Your Ref: OWPC23723
Our Ref: A/82/19/HH 27-06-2019
Please ask for:
Finlay Gardner

Single storey side/front extension.
12 Greenacres Ring Angmering

GROUND FLOOR PLAN

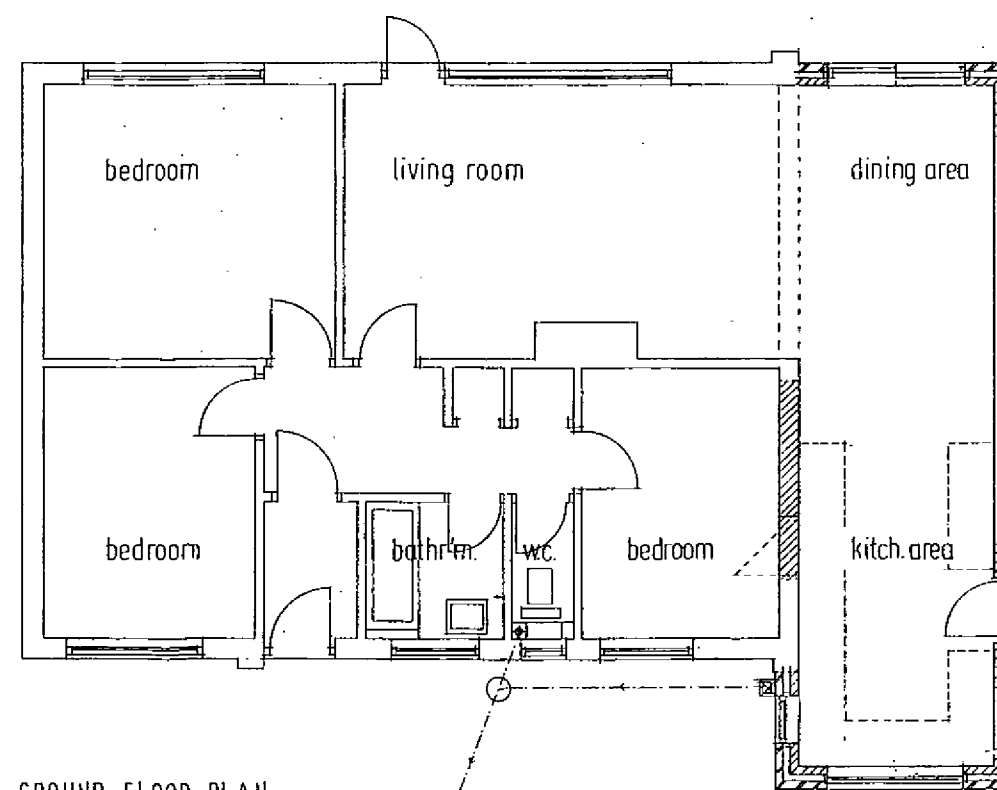
The proposed extension is 750mm from my garage which is built on a thin 1960's style concrete slab. Since the extension's foundations would need to be relatively deep I am concerned that a trench dug this close will cause subsidence.
